## Comments on the Applicant's D7 Submissions

This document sets out the comments by Cambridgeshire County Council (**CCC**) and Fenland District Council (**FDC**) (together, **the Councils**) on the Applicant's Deadline 7 (**D7**) submissions. The tables below set out the document in question that the Councils are commenting on, together with the relevant paragraph or reference number.

### 6.4 ES Chapter 6 Appendix 6A CTMP (tracked) - Rev 7 [REP7-011]

**Figure 10.1iv**  
**Cromwell Road/New Bridge Lane Signal Scheme - General arrangement**

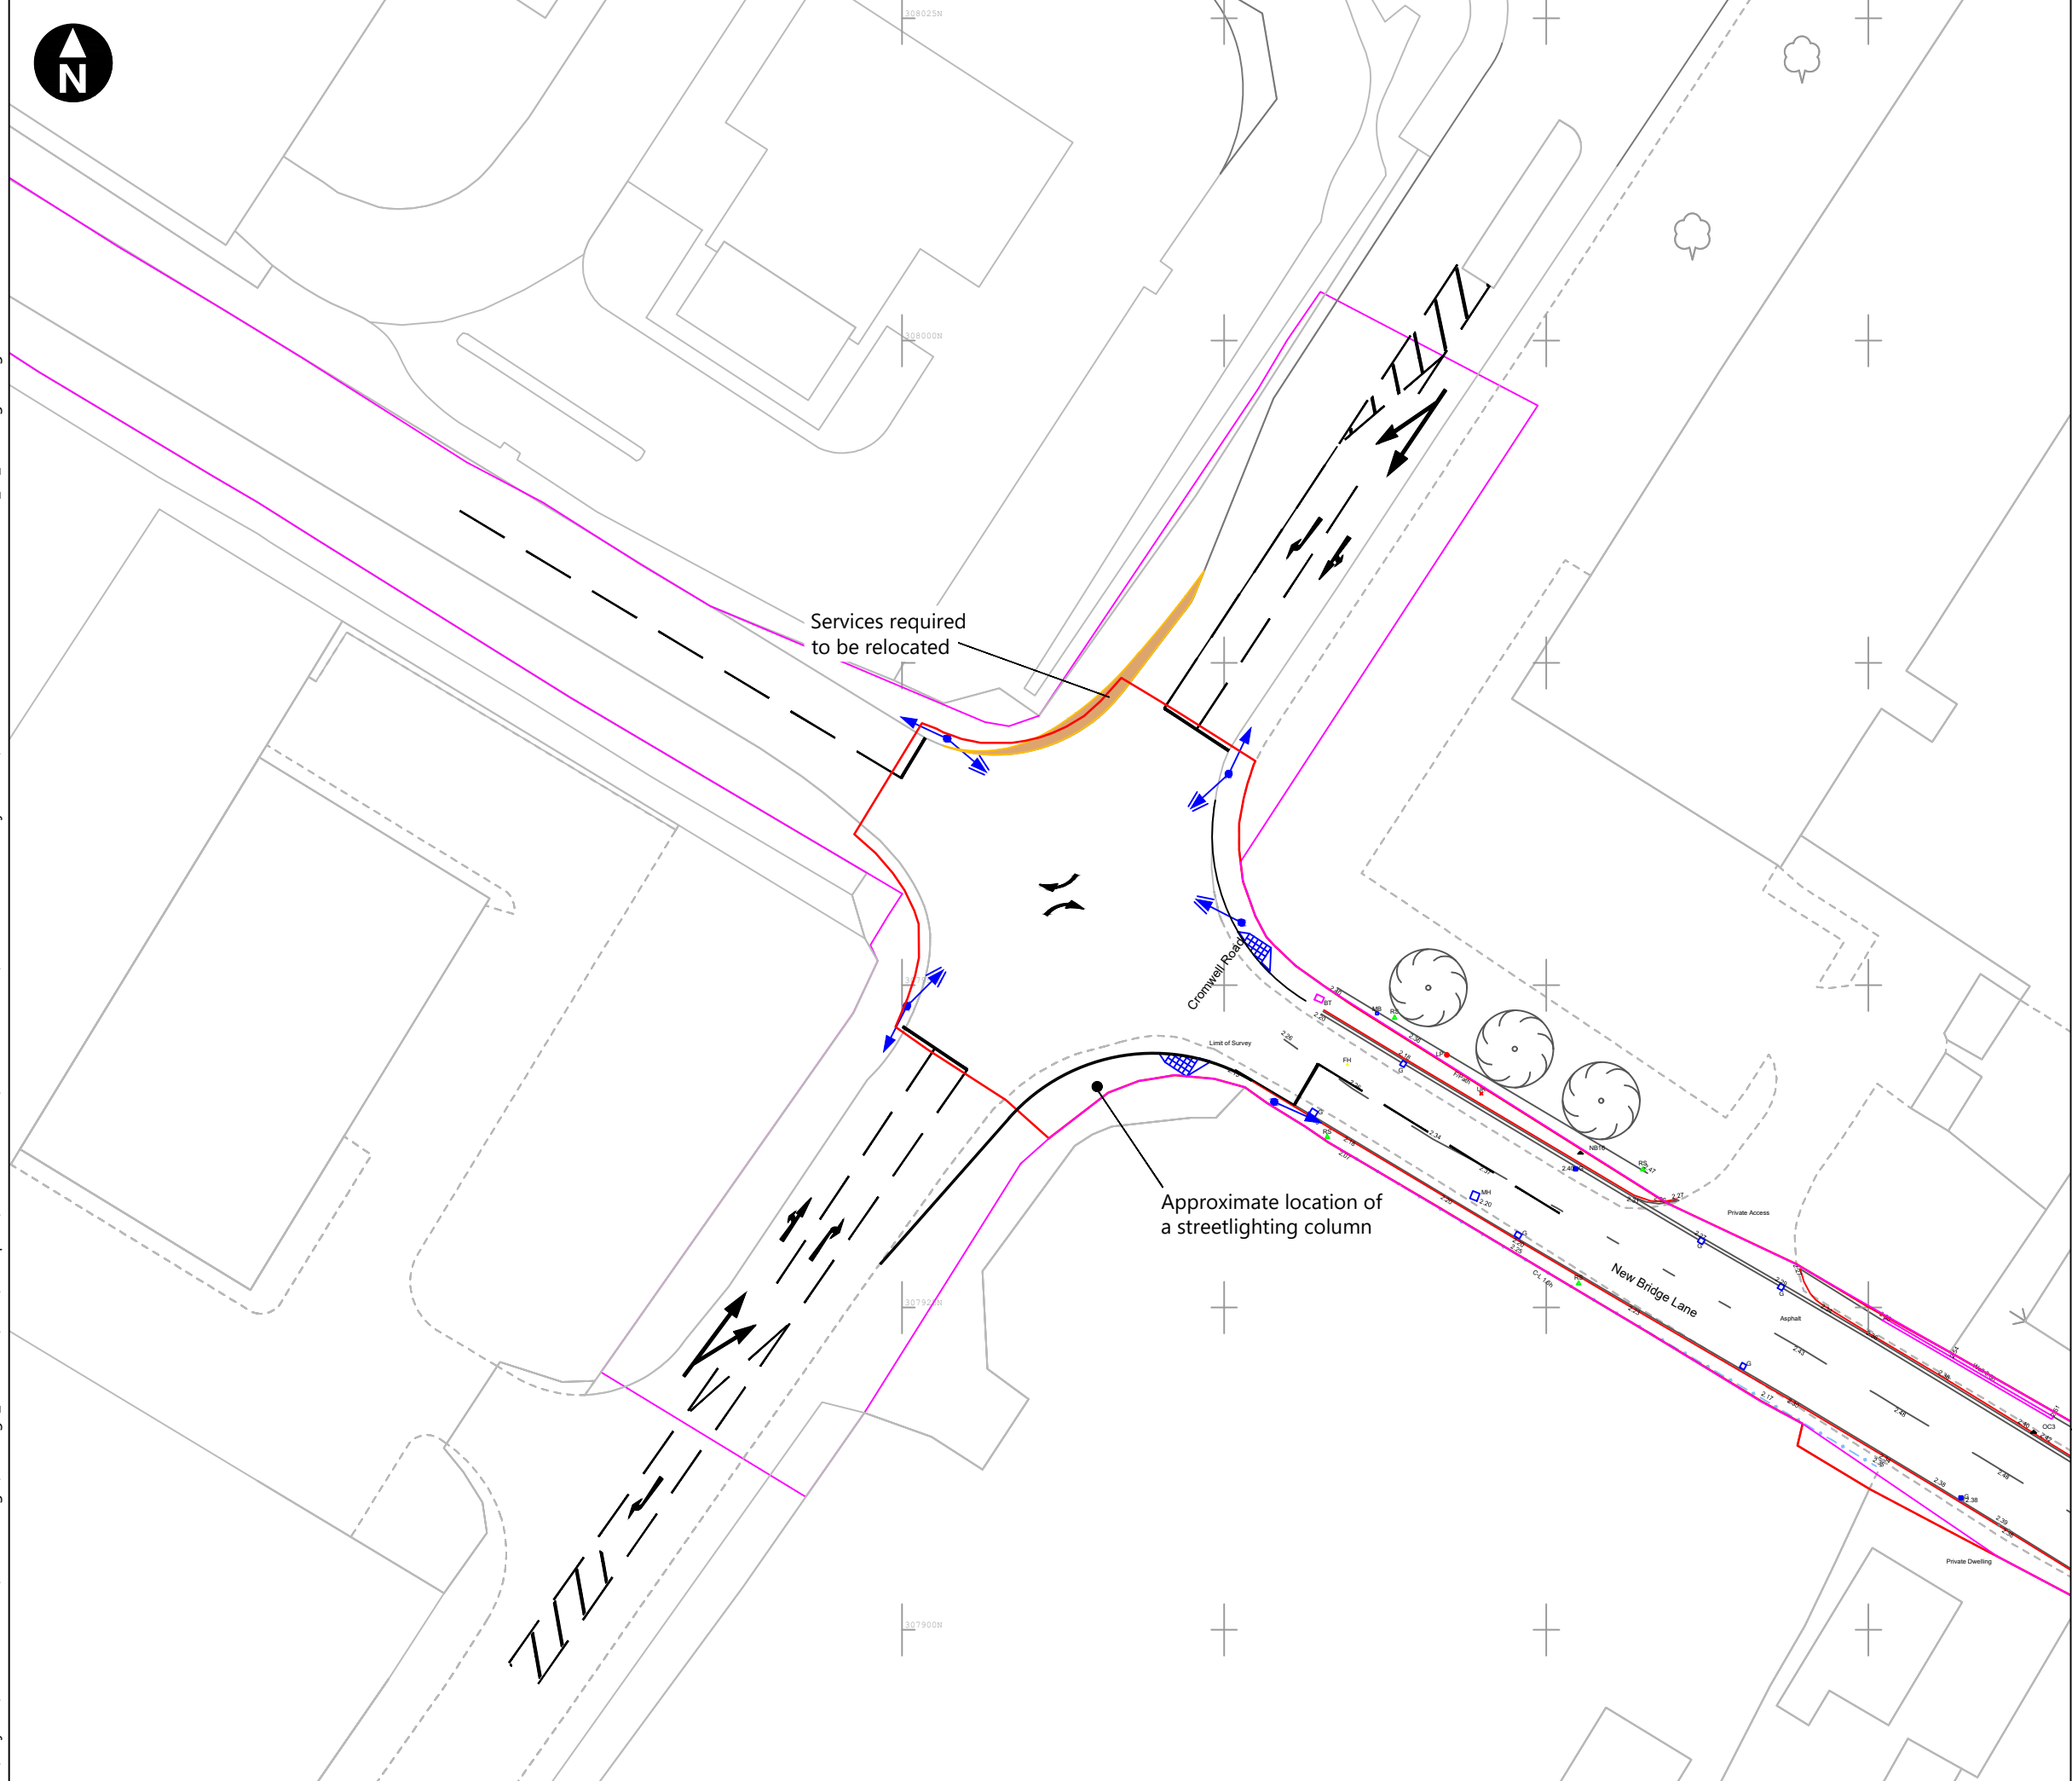
Topic	Paragraph Number	Councils' Comment
Compulsory Powers of Acquisition: New Bridge Lane/Cromwell Road junction improvements	Page 29-30, para 8	CCC notes the Applicant's comments in relation to the representations made at Issue Specific Hearing 6 and wrote to the Applicant to explain this concern in detail on 4 August 2023. CCC had previously raised concerns that the powers of acquisition included in the draft DCO would not provide sufficient means for all of the land required for the New Bridge Lane/Cromwell Road junction improvements to become highway, maintainable at public expense, specifically the land that is the subject of the Change Application (Change 1). The provision of sufficient land is necessary in order to maintain the traffic signal apparatus

required at the junction. The terms of a Section 106 agreement have been agreed and in the event that the certificate enabling adoption of the highway for Change 1 is not resolved expeditiously, there are sufficient powers included within the DCO to undertake the works. CCC and the Applicant will continue to work together to resolve the adoption of the relevant Tesco's land as public highway.
Rights of access at former level crossing	Page 31, para 10	<p>CCC notes the Applicant's comments. CCC reiterates its responsibility to assert and protect the right of the public, and its requirement to be satisfied that the two affected landowners are content with the new access arrangements to their premises.</p> <p>Following conversations with the Applicant on 15 August 2023, CCC understands that the Applicant has taken positive steps in its negotiations with Network Rail to secure private and public rights across the former level crossing, as part of the Statement of Common Ground between the parties. CCC awaits the completion of the Applicant's Statement of Common Ground with Network Rail before confirming it is content with this outcome.</p>
